**LIMERICK CITY AND COUNTY COUNCIL REPORT TO AN COIMISIÚN
PLEANÁLA IN RELATION TO PRESCRIBED BODIES SUBMISSIONS
RECEIVED IN RELATION TO BALLINLEE WINDFARM IN ACCORDANCE
WITH REQUIREMENTS OF SECTION 37 OF THE PLANNING AND
DEVELOPMENT ACT 2000 (AS AMENDED)**

ACP REFERENCE: ACP-323780-25

Figure 4-4: Map of proposed internal collector circuits

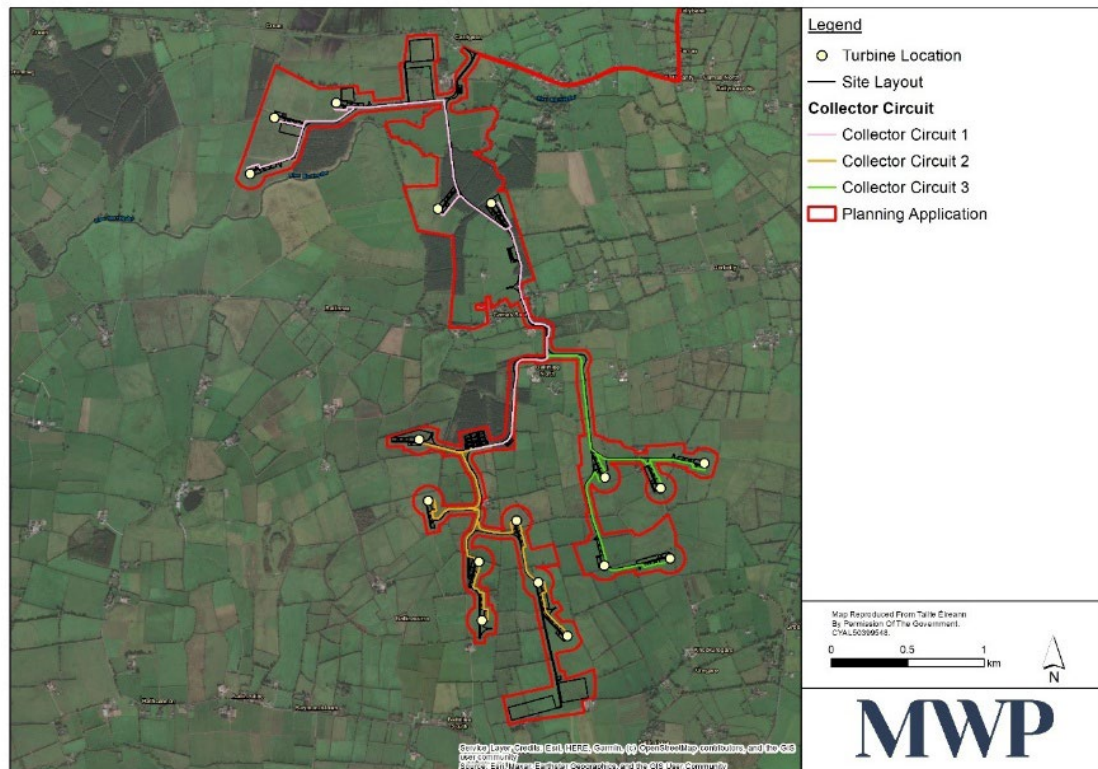
The Heritage Officer further notes that the lack of confirmation of the location of the proposed cabling route may have serious implications given that some of the bridges and crossing structures may be Protected Structures. Therefore, further information is required in order to enable a Full Assessment of the potential impact of the Windfarm cabling route 'as proposed'.

In addition, having regard to the Section 50 Consent process, should a decision be made not to give such consent for any part of the internal cabling route 'as proposed', this would mean an alternative route would be necessary, and has the potential to impact further on Protected Structures in the area. In addition, in the Director General's Report (21/11/2025) submitted to ACP the Council Road Department outlined serious concerns in relation to the feasibility and potential impacts of the proposed grid connection route given the limited information submitted with the application in terms of proposed location and design of same, and proposed enabling works.

The OPW also notes the concerns of the DAU of the DHLGH and questions the chosen route for the underground cable which passes through the Lough Gur zone given its very high possibility of archaeological finds and disruption.

• Section 50 Consent required where cable/ducting to be carried on new support structures spanning the watercourses (bridge).	2007) i.e. planning implications on foot of Section 50 Consent cannot be conditioned in any grant of planning permission for the development as proposed. As noted by OPW in their conclusion, the key aim of the Section 50 process and the recommended Flood Risk Assessment (Item 3 below) is to mitigate any increased risk of flooding and the consequences of same as arising from the proposed development and which could impact significantly on landscape, infrastructure, and people and their homes, among other things. Therefore, prior to any decision being made by An Coimisiún Pleanála, further information confirming the location of the Internal Wind Farm underground power and communications cabling route ‘as proposed’ and the impacts of same as well as detailed documentation to confirm the feasibility and potential impacts of the grid connection route and enabling works ‘as proposed’ should be sought as well as confirmation that the required Section 50 Consents are in place.

Figure 4-15: Map showing access tracks crossing GNI transmission pipeline

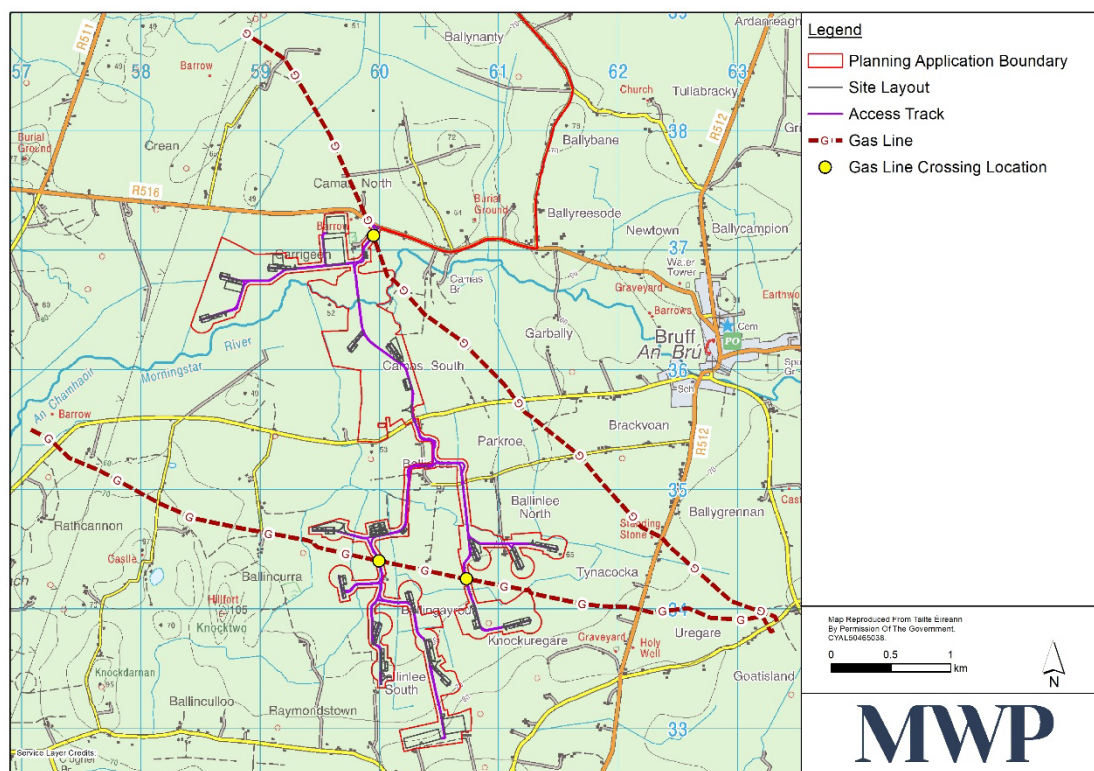
Having regard to the lack of design flexibility and given the location of key elements of the Windfarm development ‘as proposed’ immediately adjacent to 2 no. High Pressure GNI Gas Transmission Pipelines and within their associated Buffer Zones, Limerick City and County Council considers further information is required in order to enable a Full Assessment of the potential impact of all elements of the Windfarm development ‘as proposed’ on the 2 no. existing High Pressure Gas Transmission Pipelines. In this regard, prior to any decision being made by An Coimisiún, verification of the precise in-situ location of the 2 no. Gas Pipelines should be sought as well as confirmation of the exact location of all elements of the development ‘as proposed’ in the context of the ‘verified’ Gas Pipelines and their associated Buffers. This should include key elements identified above as being located in proximity to and/or within same and should include maps/drawings as appropriate. Following the above, should An Coimisiún Pleanála consider a Grant of planning permission for the Windfarm development ‘as proposed’ then it is considered appropriate to include a Condition as recommended by Gas Networks Ireland should be attached to same.
